May 4, 2005

**Re: Status of Improvement Permit Application #05-5-12005
Lot 86 Woodshire**

SITE PLAN APPROVAL

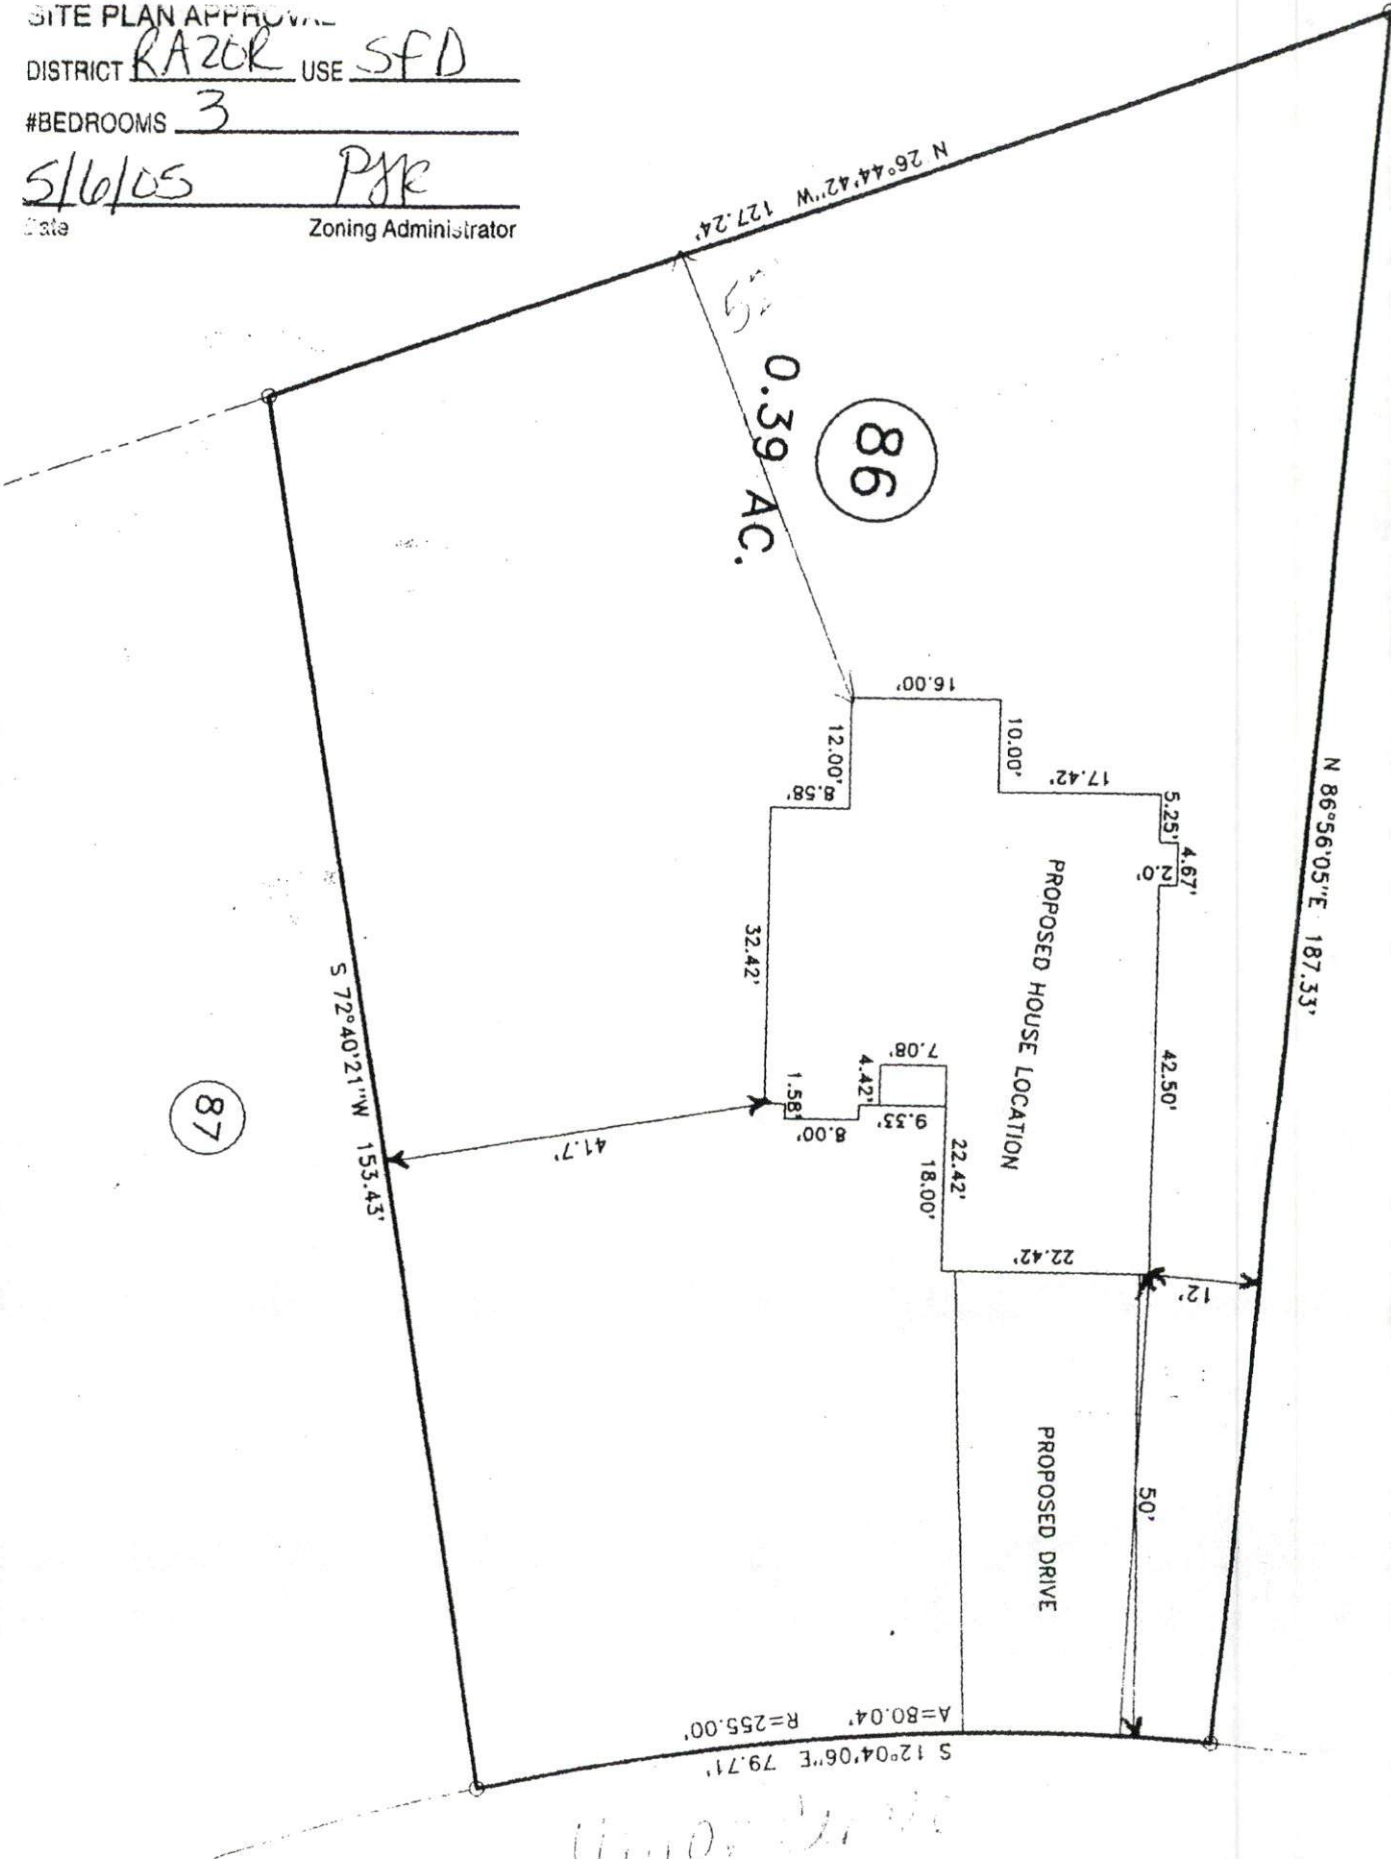
- 1. Property lines/corners not marked or labeled
- 2. House corners not marked or labeled
- 3. Directions not clear to property
- 4. Property needs brush or vegetation removed
- 5. Backhoe pits required
- 6. Other **Move house location as shown and submit changes to Central Permitting.**
